Office of
Environment
& Heritage

Our Ref: DOC16/144769
Your Ref: SSD 7487

Re: White Rock Solar Farm Project (SSD 7487) - Exhibition

Attachment 1: Detailed OEH Comments – White Rock Solar Farm Project (SSD 7487)

Figure 3.1 – White Rock Solar Farm - Vegetation zones relative to WRSF infrastructure

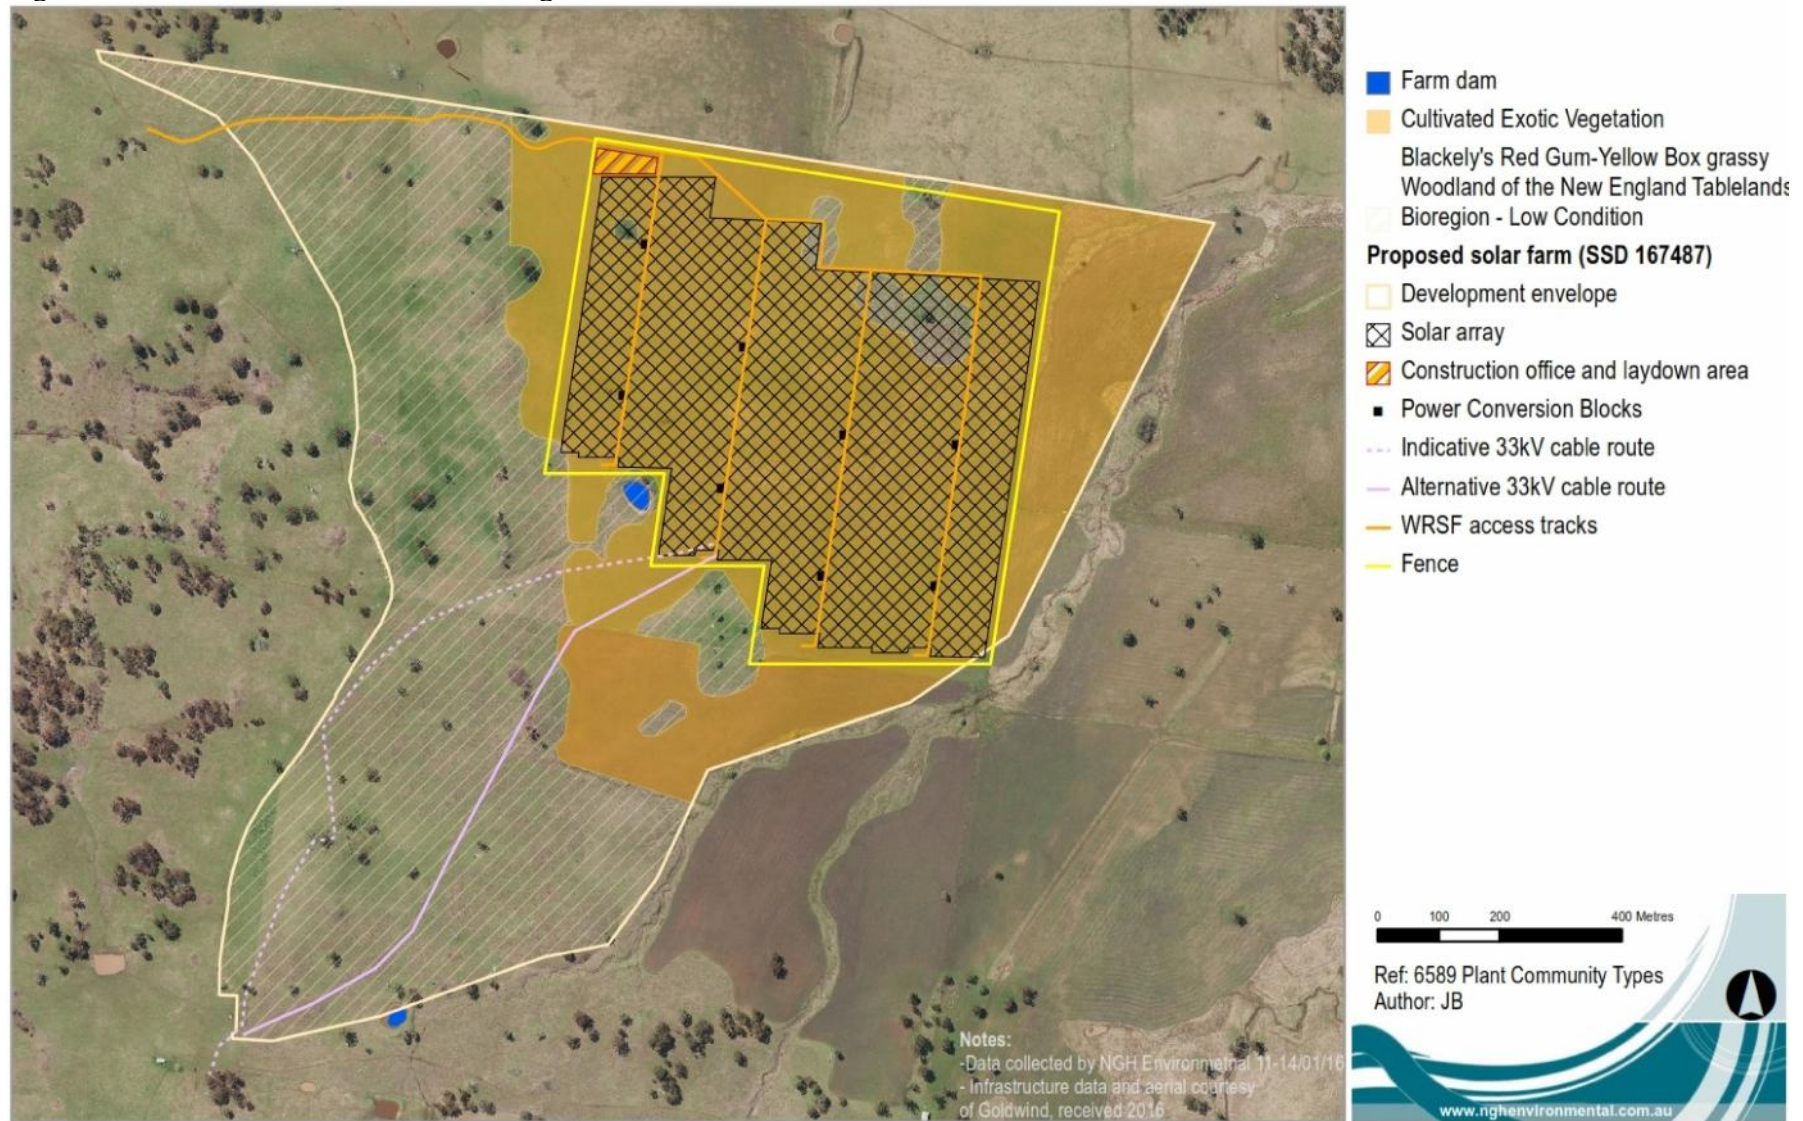
The low condition EEC is the White Box Yellow Box Blakely's Red Gum Woodland and approximately 2.93ha of this community will be impacted by the proposal. Consideration should be given to reducing this impact by reconfiguring the development layout where possible to avoid the EEC.

- Consideration should be given to reducing the impact on the low condition EEC on site by reconfiguring the development layout where possible.
- Consideration should be given to strengthening the weed management and rehabilitation of the degraded EEC on site through the proposed mitigation measures to ensure the project provides a net gain for biodiversity.

Figure B – Transects across Survey Units

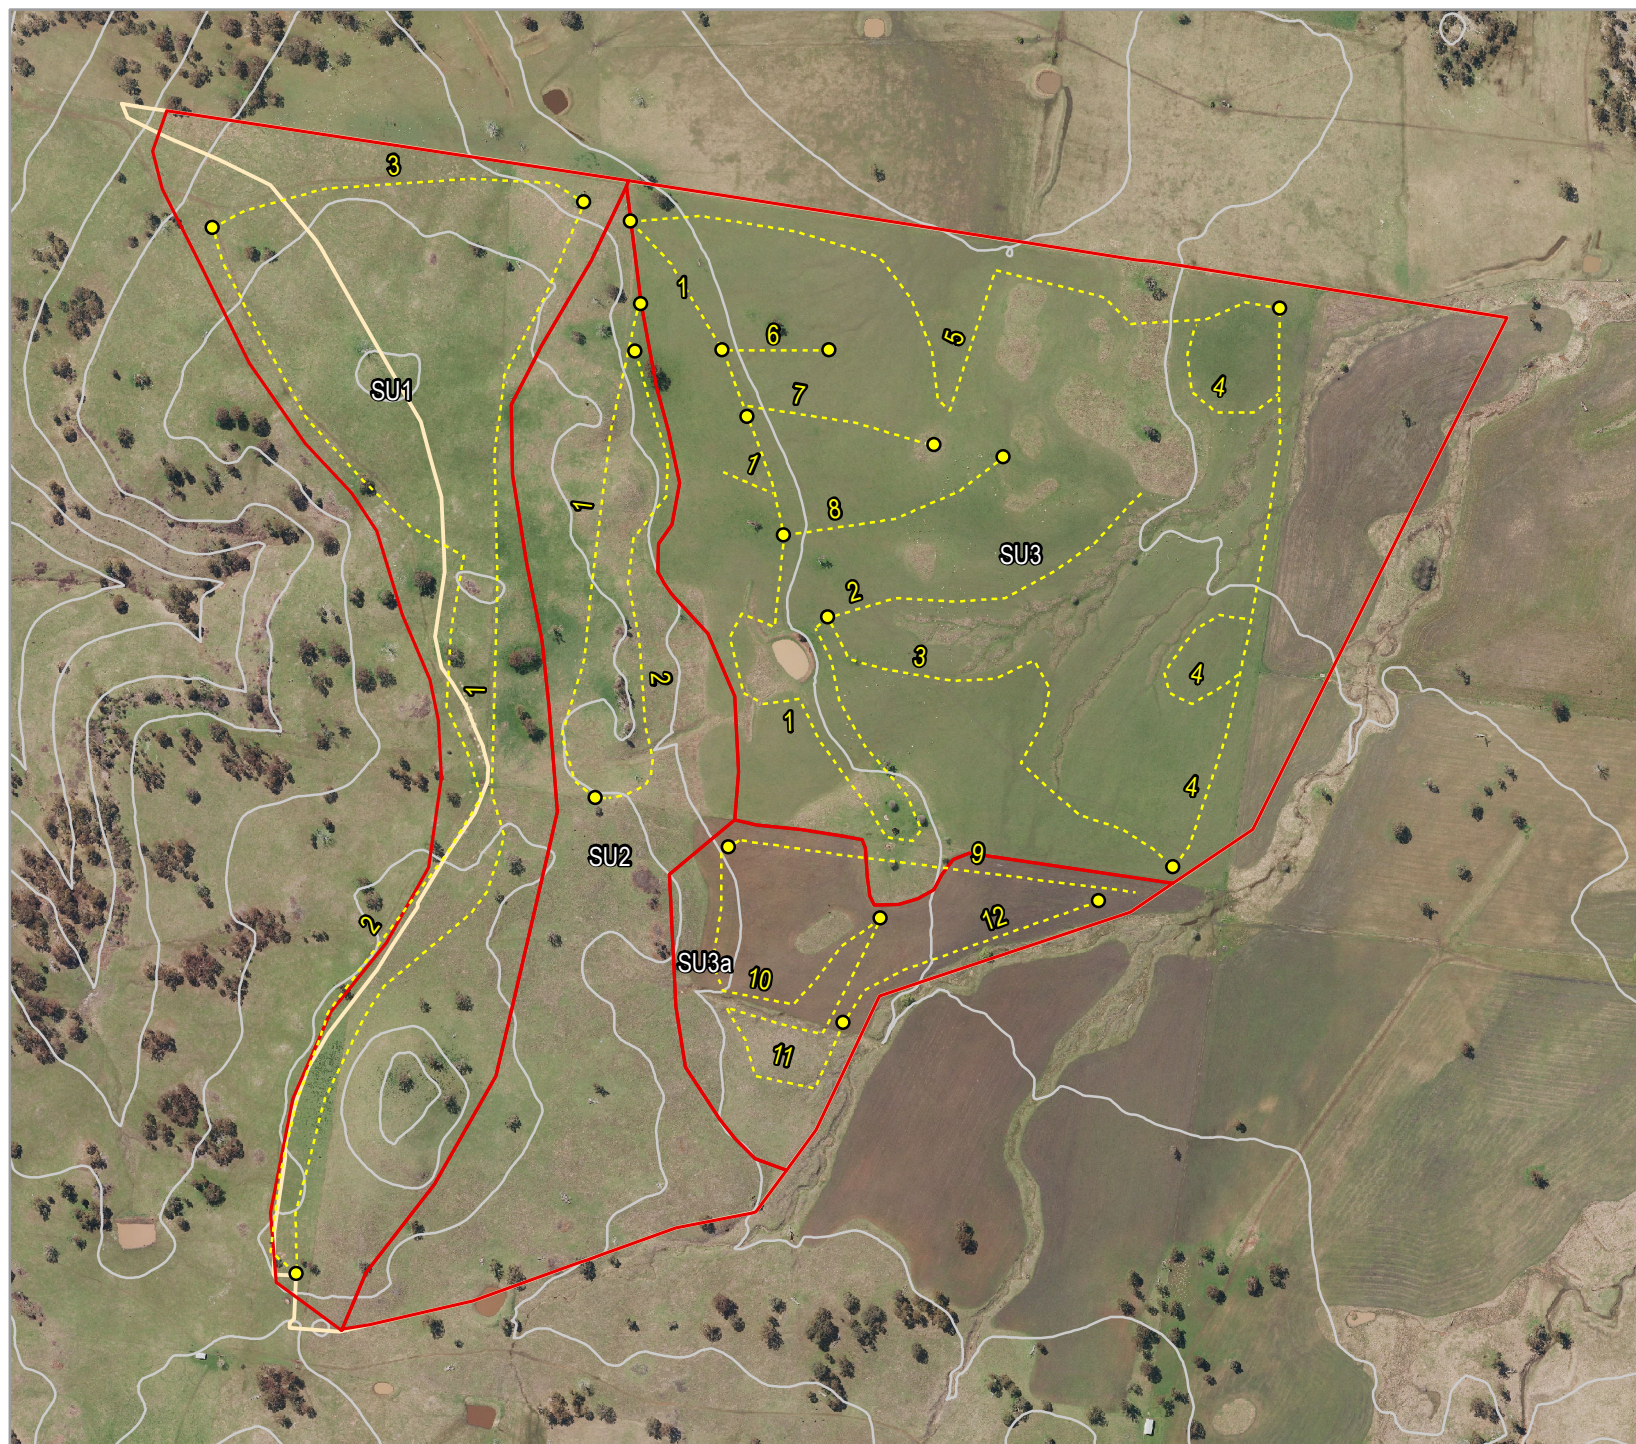
OEH considers that both the survey methodology employed and the Aboriginal Cultural Heritage Assessment Report (ACHAR) provided in support of the proposal are substandard. The effective survey coverage, particularly in area SU3A, was inadequate to accurately inform the process with regard to the likely presence of Aboriginal objects within the project area. Two prominent hill tops within SU1 were entirely avoided by the survey team and large areas within all survey units have been left unassessed.
